**Lead Local Flood Authority**  
**Post Point CHN 215**  
**Hertfordshire County Council**  
**County Hall, Pegs Lane**  
**HERTFORD SG13 8DN**

Date 10 October 2016

**RE: 6/2016/1677/MAJ - Blue Moon Paddock, Woodfield Lane, Brookmans Park**

Appendix 2: Proposed Site Plan

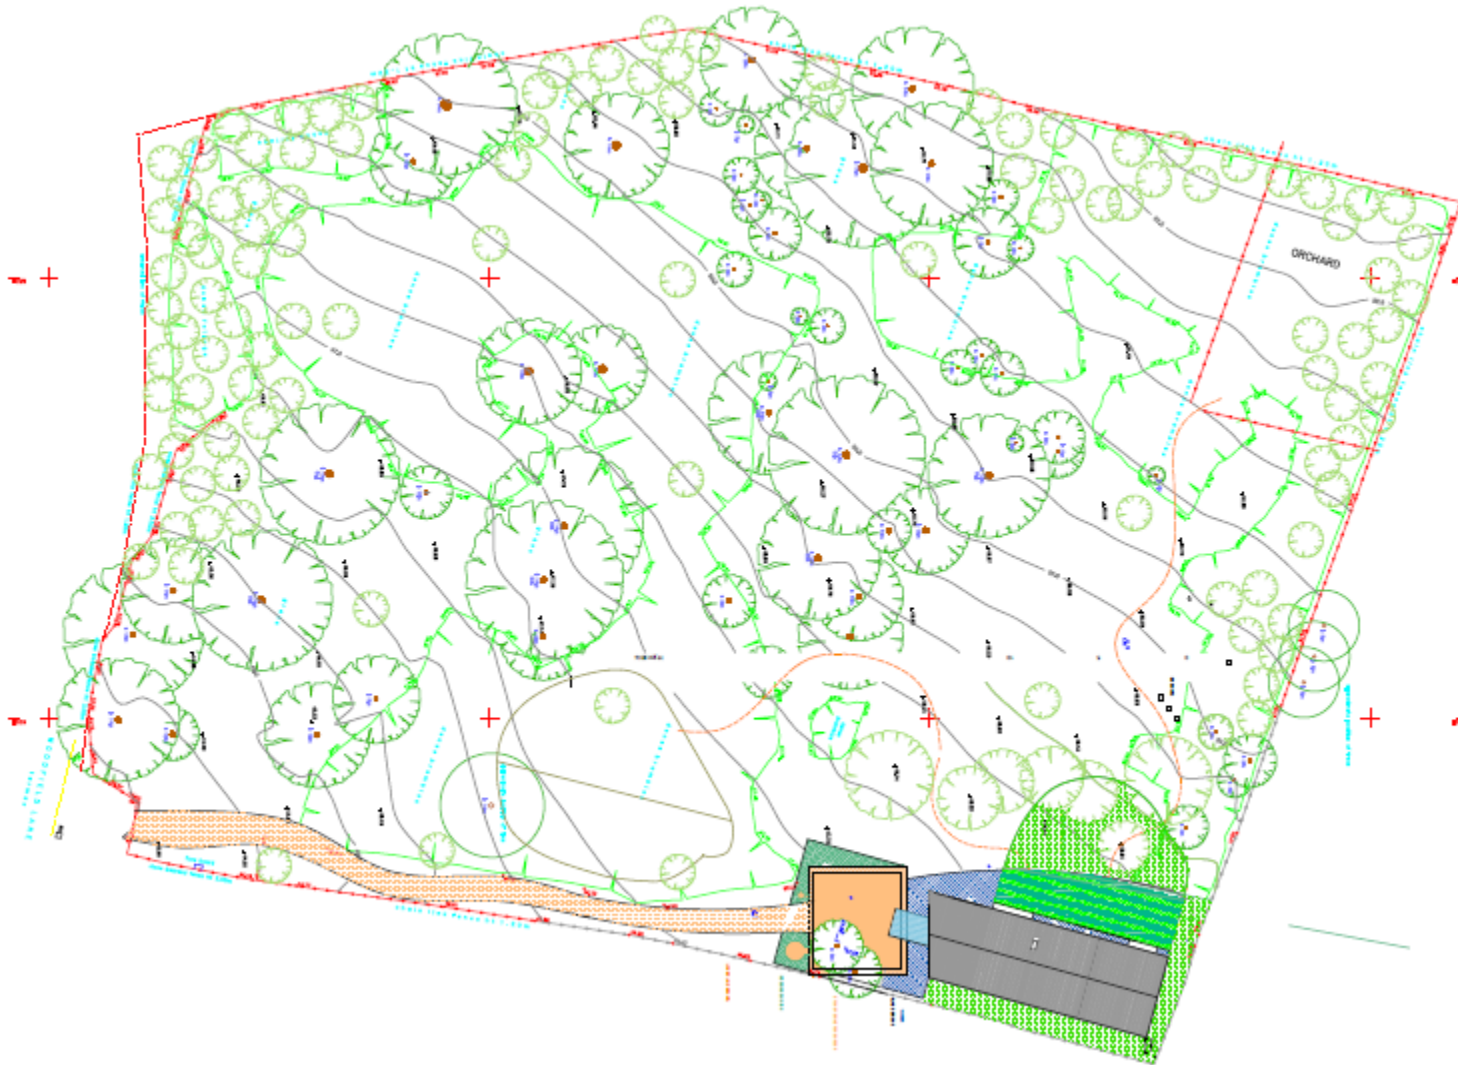
The FRA also states the swale will be connected from the roof area of the proposed dwelling. However it does not explain how this connection is going to be made. The Proposed Site Plan, drawing No. P/302/A, dated of 19 Feb 2015 presents the location of the dwelling that is going to be erected. However it does not highlight the car parking location and the impermeable areas.

No development shall take place until a surface water drainage scheme for the site, based on sustainable drainage principles and an assessment of the hydrological and hydro geological context of the development, has been submitted to and approved in writing by the local planning authority. The drainage strategy should demonstrate the surface water run-off generated up to and including the 1 in 100 year + 40% for climate change critical storm will not exceed the run-off from the undeveloped site following the corresponding rainfall event. The scheme shall subsequently be implemented in accordance with the approved details before the development is completed.

- Updated site characteristics and detailed calculations of proposed surface water storage volumes and flows with initial post development calculations/ modelling in relation to surface water are to be carried out for all rainfall events up to and including the 1 in 100 year including a 40% allowance for climate change.
- Final drawing with the total impermeable area, showing the location of the different impermeable areas including the car parking.
- Final drawing showing the drainage scheme including the point of the discharge of the surface water and location of other proposed SuDS.
- If infiltration is proposed, infiltration test carried in accordance with BRE Digest 365 to ensure the feasibility of the scheme must be provided.
